Application by Highways England for an Order Granting Development Consent for the A38 Derby Junctions Scheme

The Examining Authority's first written questions and requests for information

Response on Behalf of Derbyshire County Council

Little Eaton Junction Improvements

**Little Eaton Junction Existing & Proposed Rights of Way Plan**

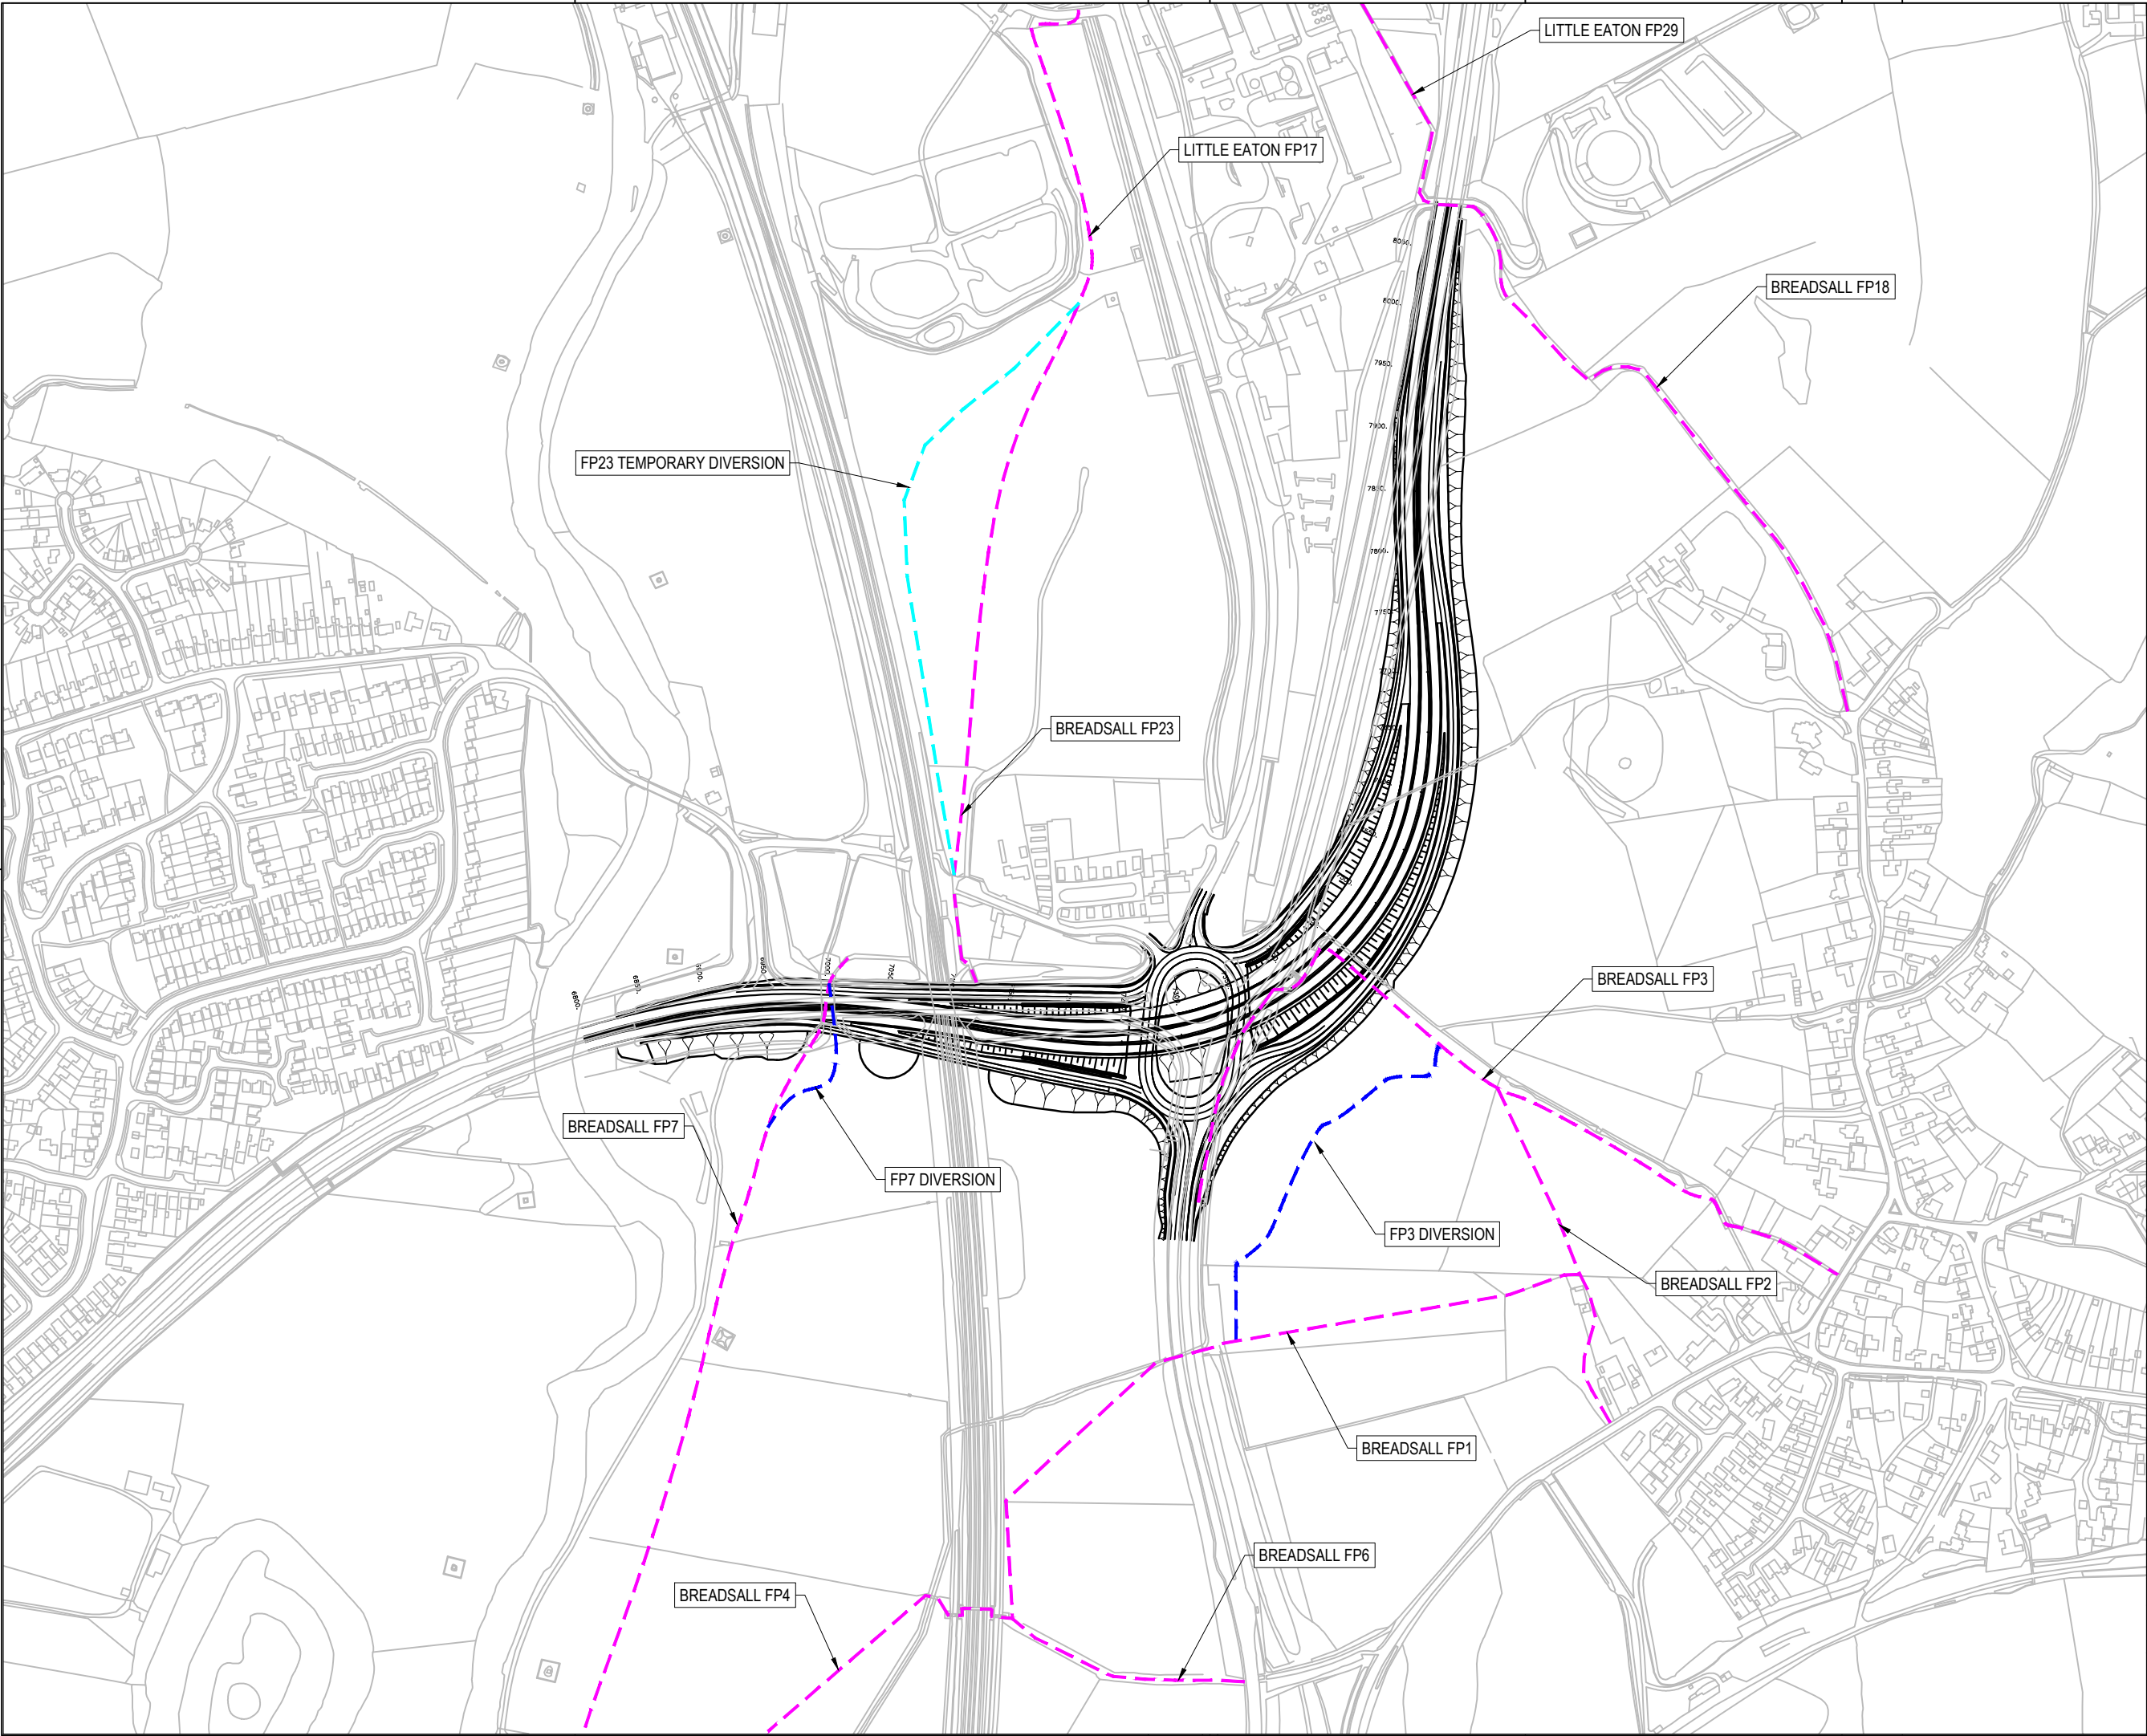
<p>1.6</p>	<p>Do DCiC or DCC have any comments in addition to those provided in their RRs on the provisions to be secured in the dDCO in their area for:</p> <ul style="list-style-type: none"> • trunk roads; • classified roads; • unclassified roads; • speed limits; • traffic regulation measures; • revocation and variations of existing traffic regulation orders; or • public rights of way? 	<p>DCC has recently completed the scheme to provide a shared cycle/pedestrian footway on the A61 Alfreton Road, Little Eaton (<i>Between Pektron Roundabout and Little Eaton Roundabout</i>). It is the widening of the western side footway to 2.5m and connects into the existing cycling provision on the A38 Abbey Hill via the signal controlled crossing points. It provides a link to the north onto the B6179 into Little Eaton and a link to the west on the A38 and into Ford Lane.</p> <p>One of the issues which has been raised in the past is the current right of way which comes out of Breadsall village (Little Eaton Junction Consultation Brochure Drawing) shown as the Dam Brook trail which runs from the village towards the A38 and then follows the current alignment of the A61 around and comes out at the side of the A61. There is physical evidence through a worn section of grass in the middle of the A61 where pedestrians have been standing in the past to cross over the A61. It would appear that the route is used by people wishing to access the Northbound bus service at the nearby stop provision on the A61.</p> <p>One of the possible ideas was to divert the right of way (Dam Brook) from the back of the village at a perpendicular angle straight to the A61 edge (shortest route), however the scheme drawing showed it being diverted around the back of the surface water management ponds and coming out at a similar location at the A61 to where the current informal crossing type arrangement exists (see above). Irrespective of which route the path takes from Breadsall village, it is expected that this will be constructed to a suitable standard i.e. top trek type material with defined edging. It is likely that,</p>

<p>should the right of way be of a good standard, it will encourage an increase in footfall to and from Breadsall village as it will be an improvement on the current provision.</p> <p>An issue in respect of the current proposed arrangement is that the path would come out in close proximity to the roundabout and as the road is of a higher speed limit, vehicles exiting the roundabout/A38 would enter the A61 and be in potential immediate conflict with pedestrians and other vulnerable road user groups crossing at this point, in addition to which at peak times if a controlled crossing was on red for vehicles this could have potential for queuing back onto the roundabout.</p> <p>The proposals previously did not make reference to whether the realignment of the Dam Brook would be of a sufficient width that it could accommodate both pedestrians and cyclists. Nor does it make reference as to what standard of construction it will be. Clarification on these points from Highways England would be welcomed. At this point on the A61 it is evident that the ability to then cross the A61 Alfreton Road to access the western side of the road for recreational purposes (walking, cycling) travel purposes (north bound bus stop and its services) or to pursue a route into Little Eaton village to the South, is restricted.</p> <p>DCC as the Highway Authority recognise the difficulty in people being able to safely cross the A61 and DCC has received many communications from residents and the Parish Council of Breadsall village with regard to this matter. DCC's officers have met with Highways England in respect of the scheme for the A38 and in particular the area around the Little Eaton roundabout. DCC has made representation</p>

<p>through the consultation process for this scheme that the County Council would wish to see the implementation of a pedestrian crossing near to the Croft Lane access onto the A61.</p> <p>This would be of a sufficient distance from the roundabout and that approaching vehicles would have sufficient time and distance to react when the crossing point is activated, and reduce the potential for vehicles to be queuing back onto the A61/A38 junction.</p> <p>To facilitate a scheme of this nature would require the need for the construction / continuation of the Dam Brook Trail down the Eastern Side of the A61 from the proposed current end of the facility near the ARMCO barrier as a footpath construction to connect to the existing Bus Stop provision and into the Croft Lane existing cycle/pedestrian footpath would be required. This would then allow for a safe and suitable crossing point that connects both the north and south bound bus stop provision on the A61 and the new shared pedestrian/cycle path on the western side of the A61 that has recently been constructed.</p> <p>The installation of a pedestrian crossing would address the number of enquiries that the County Council has received for consideration to be given for the introduction of a formal crossing arrangement for the A61 Alfreton Road as the perception is that people don't have a safe and suitable facility to cross the busy, high speed dual carriageway of the A61. This improvement to the Dam Brook trail and the highway improvement scheme to the western footway, the shared footpath scheme for the A61 Alfreton Road is likely to</p>

<p>encourage/promote an increase in demand for people wanting to cross the A61.</p> <p>In reference to (Little Eaton Junction Consultation Brochure Drawing) the signalised crossings specified in and around the approaches to Little Eaton roundabout the drawing does not specify whether these are toucan crossings that will provide the necessary network links/connectivity to the cycle route provisions within the surrounding area. Clarification would be welcomed from Highways England on this point.</p> <p>To facilitate the provision of a pedestrian crossing on the A61 the existing National Speed Limit would need to be reduced to 50mph to accommodate a Toucan (pedestrian crossing). Highways England have already stated in correspondence they are prepared to fund such provision, and therefore DCC would wish to see a formal design from HE that is acceptable to the Highway Authority.</p> <p>In addition there is a Key Cycle Network, which includes a proposal for Little Eaton Branch Line which would utilise the existing network off the B6179 along Ford Lane, with an intention to create a crossing over the rail line and into an off-road cycle track heading north towards Duffield.</p> <p>In addition DCC undertook improvements to the Public Transport provision on the western side of the A61 at Breadsall during the construction of the shared pedestrian/cycle route. However, the existing bus stop provision on the eastern side of the A61 is in need of a scheme of improvement. The existing bus shelter at the stop is life expired and in need of replacement, in addition to the lay-by not being of a construction/layout that meets current Bus Quality Partnership standards and would need to be</p>

<p>amended to meet the current service demands for the residents of Breadsall village which would be encouraged to use when the right of way issues are resolved and a safe and suitable crossing provision of the A61 is implemented. Therefore DCC would look to seek improvements to this location as part of the scheme Little Eaton Junctions Scheme.</p>
